XAVIER
KNIGHT

28th January 2025

SSDA Rail Engineering Stormwater RFI
2-8 Wilson Street & 849-859 Pacific Highway, Chatswood
NSW 2067

Sheet Subject  
**GENERAL ARRANGEMENT PLAN**

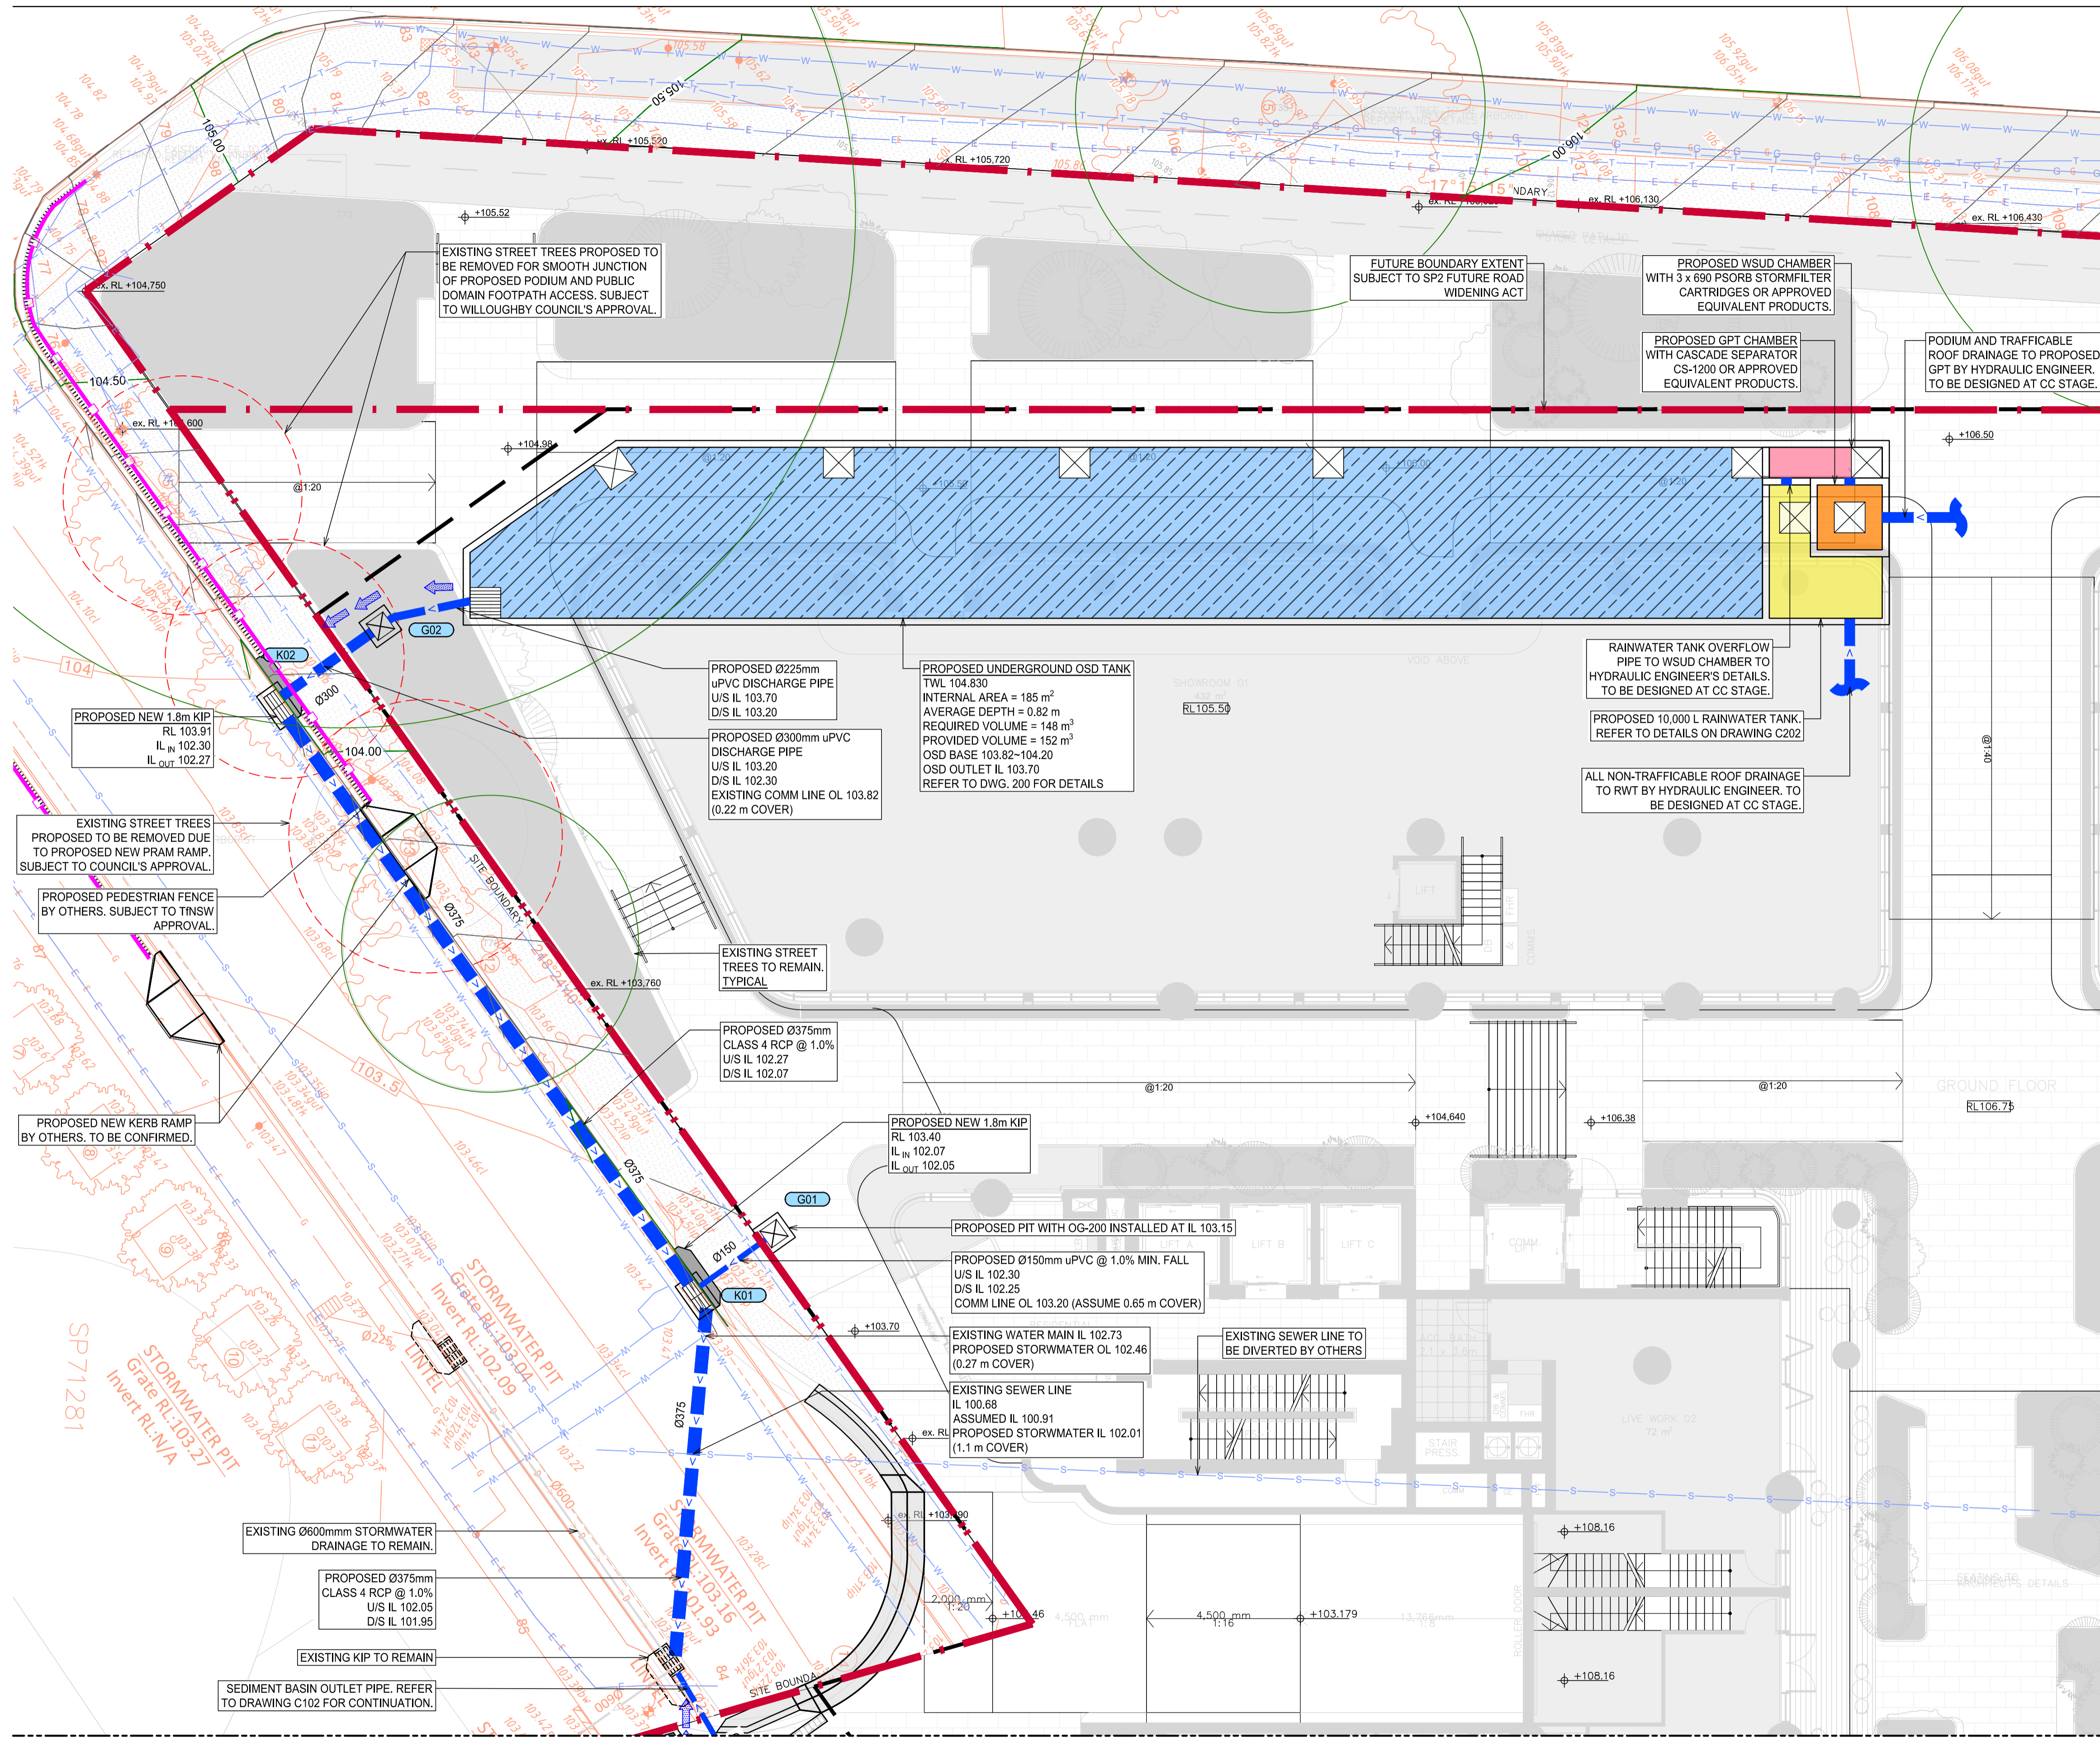
"The catch drains along the top of the retaining wall, shown on the retaining wall as-built drawings, would require capacity to convey a 2% AEP safely to the track drainage at the bottom of the retaining wall. The proponent's preliminary stormwater management plans do not direct any stormwater runoff towards the rail corridor. It is noted that the plans do propose to remove the existing retaining wall catch drains (drawing C300). It is recommended to retain this as part of the wall structure with further assessment required during the next phase of the project. If it is not possible, the design must demonstrate no impacts to the rail corridors drainage performance for up to a 1% AEP."

Drawing C100 shows that the overland flows through the site are conveyed to the above ground On-Site Detention (OSD) Basin. In minor storm events, these flows are conveyed to the OSD using stormwater pit and pipe network proposed for the development. In larger storm events, these flows are conveyed to the OSD using 150mm high kerb. The remaining area draining to the dish drain is pervious landscaping and as such will collect reduced runoff compared to the pre-development scenario. The existing dish drain will be retained and protected during construction. It has been incorporated into the design with the landscaping levels to match flush into the existing edge of the dish drain.

The discharge point for all flows generated from the development including upstream catchments are at the existing sag pit in O'Brien Street. Refer to Appendix A for drawing C100.
